ROLLIN RIDGE Filing No. 1 Grading & Erosion Control El Paso County

Update to "Engineering Record Drawings"

"RECORD DRAWINGS"
REVISED TO CONFORM WITH
CONSTRUCTION RECORDS
8/26/22

SHEET: **G2**

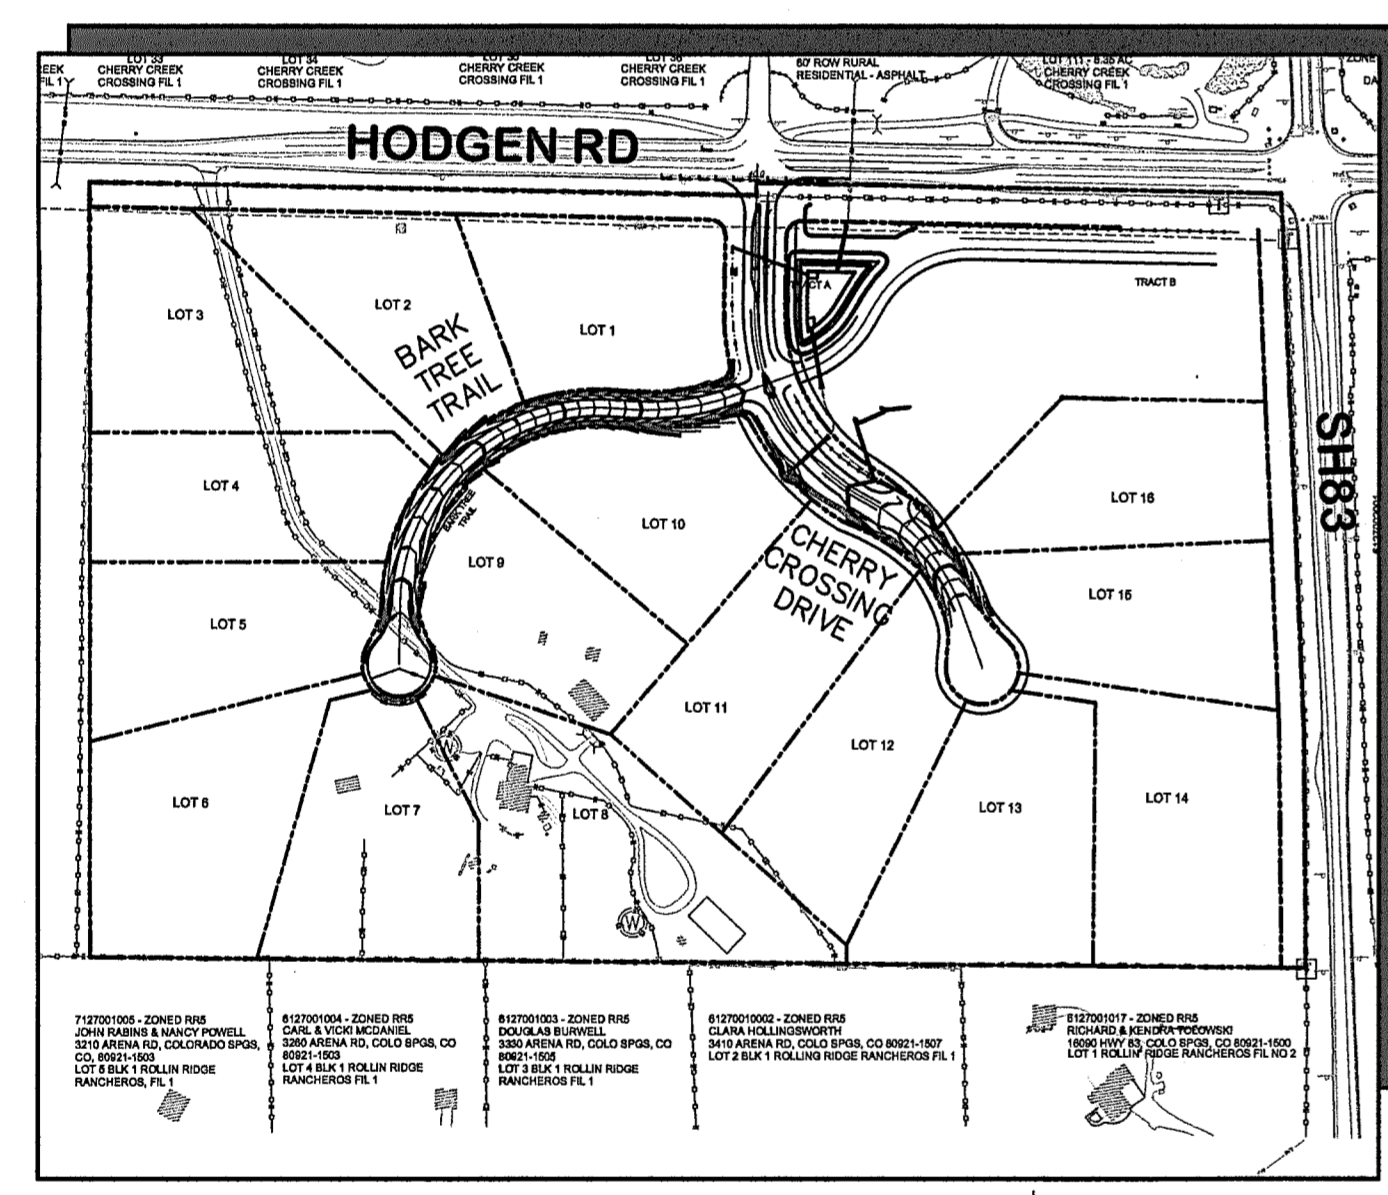
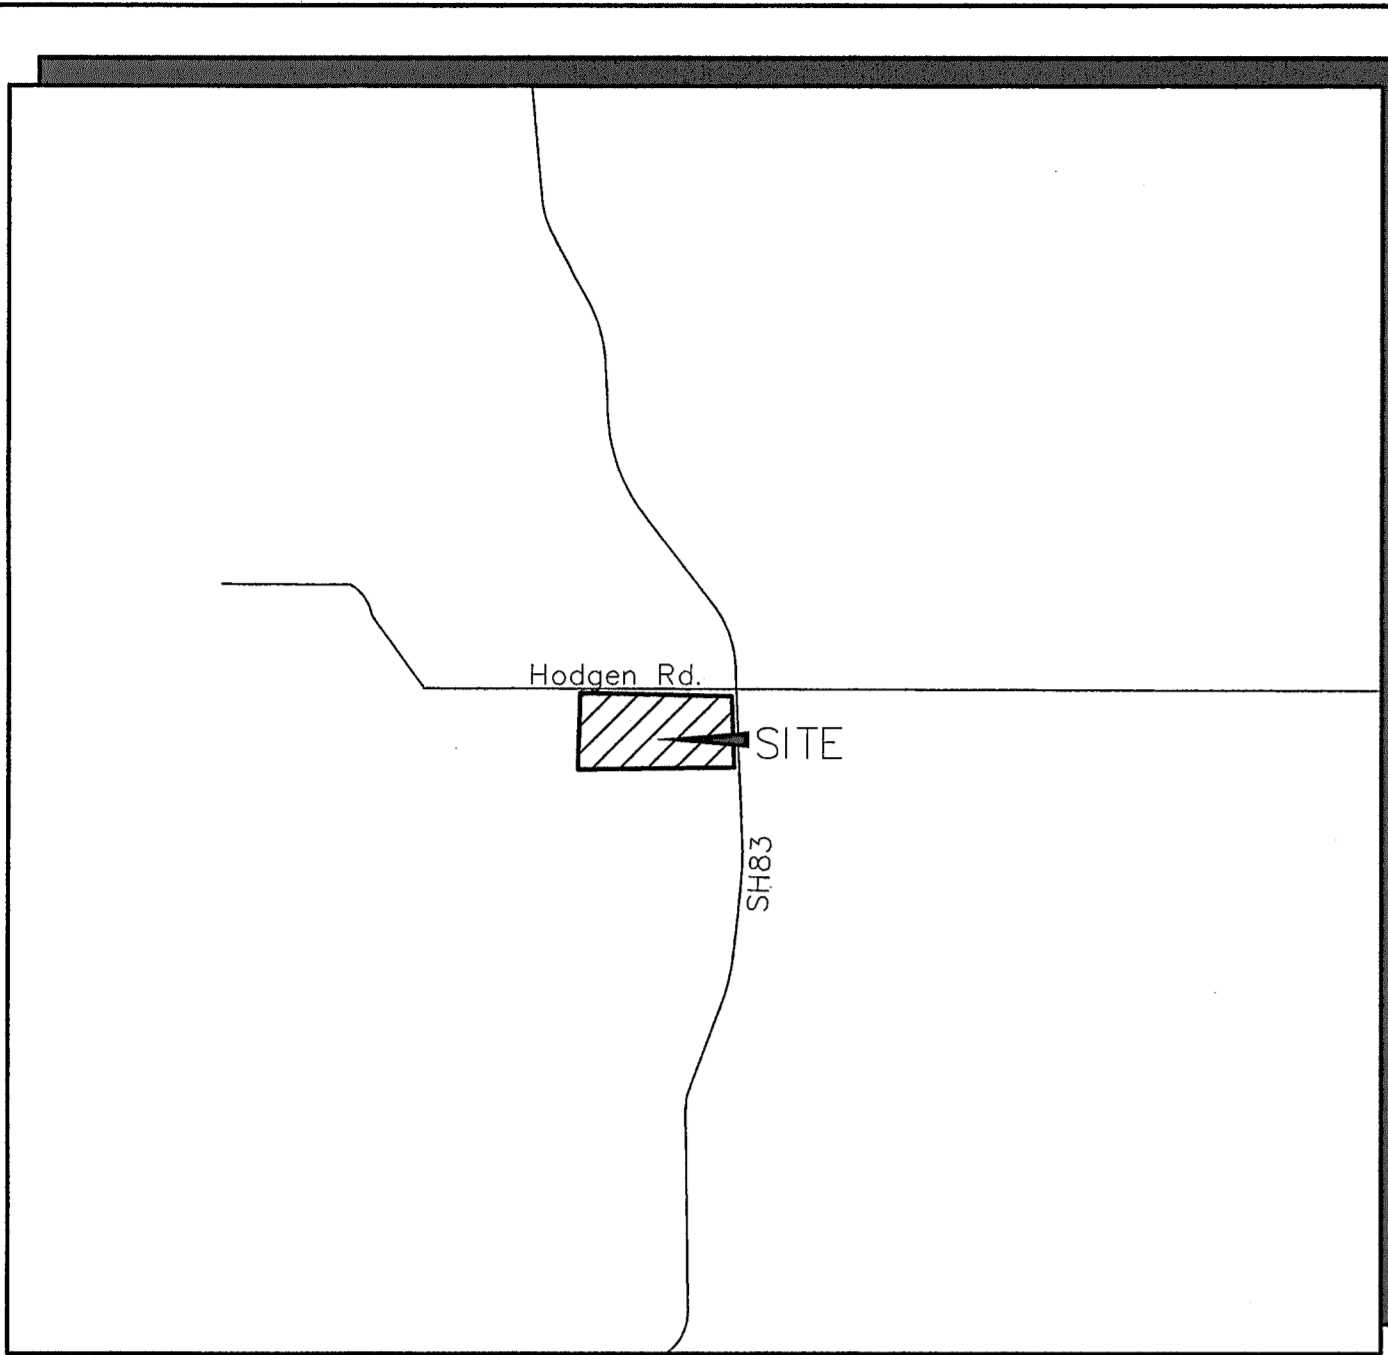
Submit As-built of the Street Construction Drawings and Signage and Striping Plans per ECM 5.10.6

Replace with the approved CDs. Per ECM 5.10.6.B the revisions shall be shown on a copy of the original approved construction plans

Alternative is to stamp/sign all sheets that were revised from the original approved documents.
